Planning Application Ref: BE/27/20/PL

Location: Land at Salt Box, West of Shripney Road, Bersted

Description of works: Creation of temporary soil storage bund & haulage route associated with development of adjoining site at Saltbox (resubmission following BE/38/19/PL). This application may affect the character & appearance of the Shripney Conservation Area & is a Departure from the Development Plan

Tree Officer / Parks and Greenspace Team

TOP SOIL RELOCATION  
 SITE PLAN  
 1744-TS-P02-E

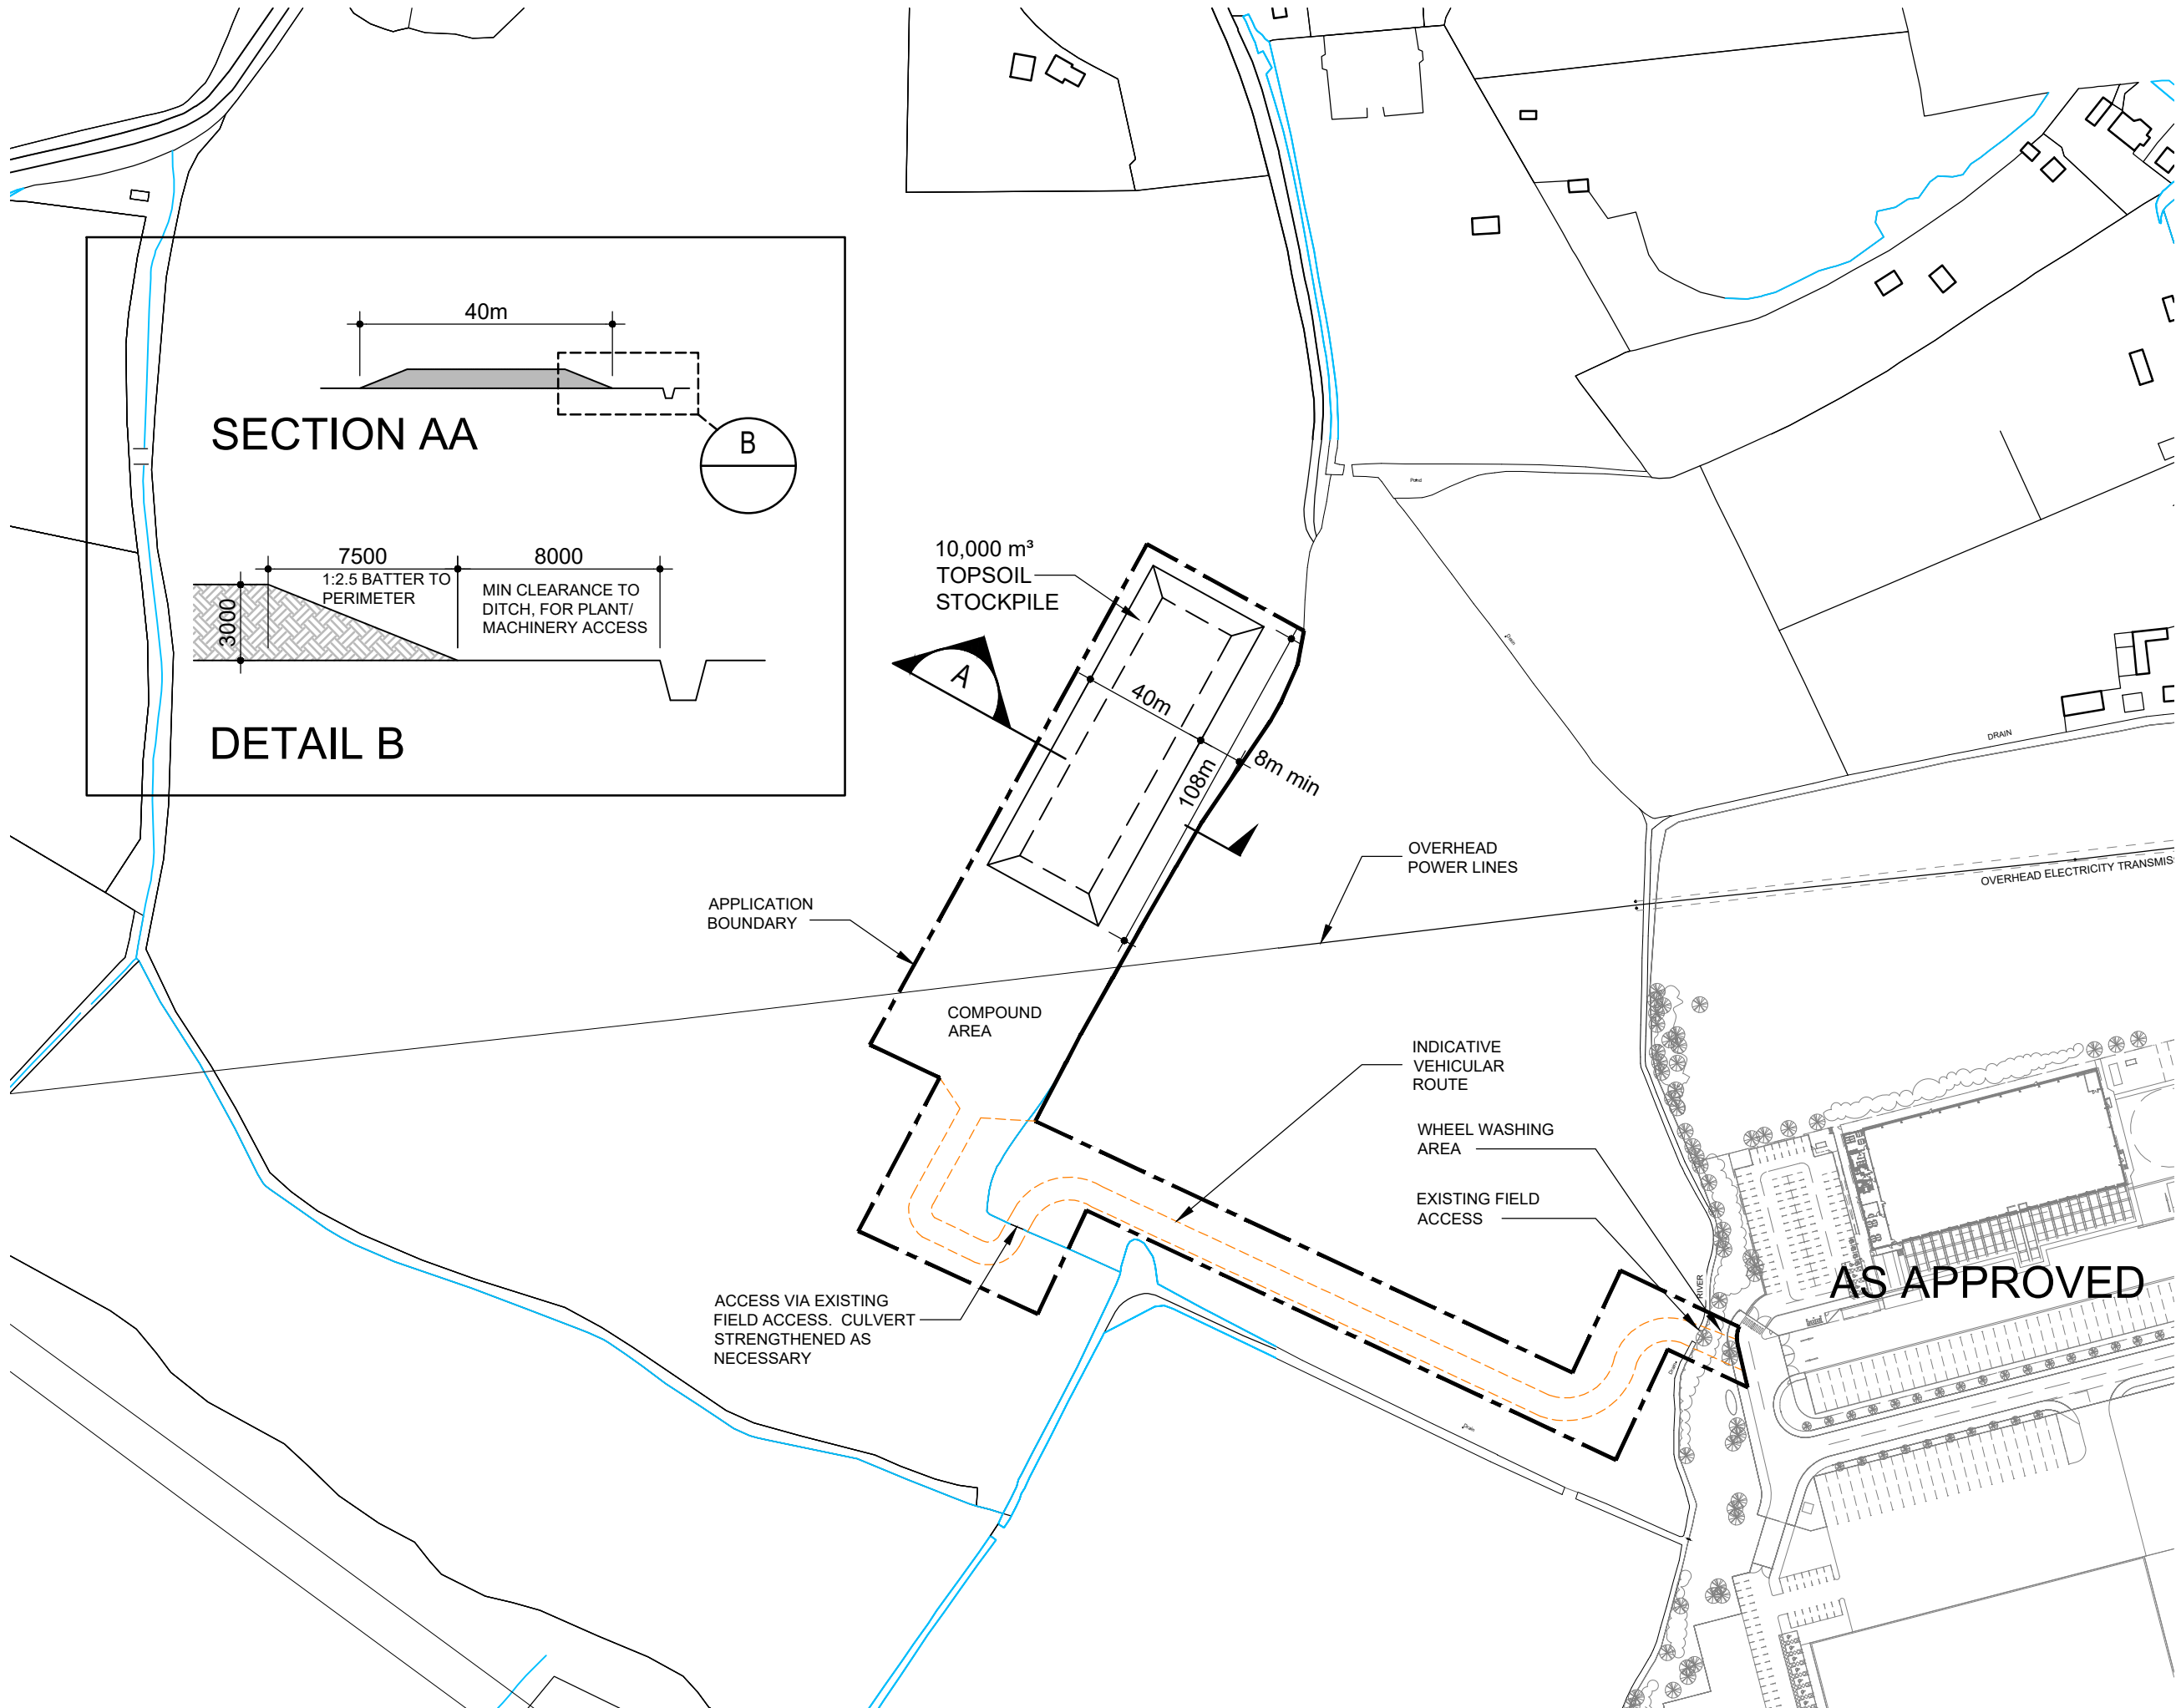
- Use of the existing farm tracks is acceptable, although I doubt they have carried the quantity and weight of plant now proposed. As such, there is a risk of new levels of soil compaction with potentially harmful effects on tree growth. I have no issue with the use of such tracks until we enter the field where the soil is to be stockpiled. The LVTBN (para.3.2) describes *'the topsoil stockpile will be set back from the adjacent field boundary and ditch existing by a minimum of 8metres.'* This is illustrated later in Appendix 2 (p9, inset drawing Detail B) along with text describing access for plant/machinery within 8metres from the hedge boundary. The largest hedgerow tree in proximity to the stockpile is a maturing ash with a stem diameter at 1.5m approximately 600mm. This translates ordinarily to a nominal circular root protection area of 7.2metres radial spread. **There is ample room to avoid travel into the 8m zone, which I would prefer described as an exclusion zone so that all activity associated with this development is prohibited in that zone. The extension of this exclusion zone south by approx. 40metres and to protect the entire hedgerow length to be shown on the aforementioned drawing.**

- The ditch/tree and hedgerow buffer zones are not extensive enough nor adequately described and there exists potential for movement of heavy plant over soft ground within those zones (and potentially within nominal root protection areas of trees and hedgerow). More information and greater clarity within the LVTBN please, required as **highlighted above.**

- The precise extent of hedgerow removal to accommodate heavy plant access through the site has not been specified in detail. This should be described in detail (metreage and any treatment of stumps) and illustrated on a scale map, much as would be required for an application or notice under the Hedgerow Regulations 1997.

1. The applicant should provide us with a revised Landscape and Visual Technical Briefing Note that confirms; the route of heavy plant across the site and around the stockpile, full extent of extended 8metre exclusion zone, extent of hedgerow removal at field access points; so that we can be confident retained on/off-site trees and hedgerow will not be negatively impacted throughout development. On receipt of a suitably revised LVTBN, it will need to be included in a condition forming part of any APPROVAL.
2. As it stands, I am unable to lend this scheme my support and so register an **OBJECTION**, although expect that to be easily overcome with a suitably revised LVTBN.
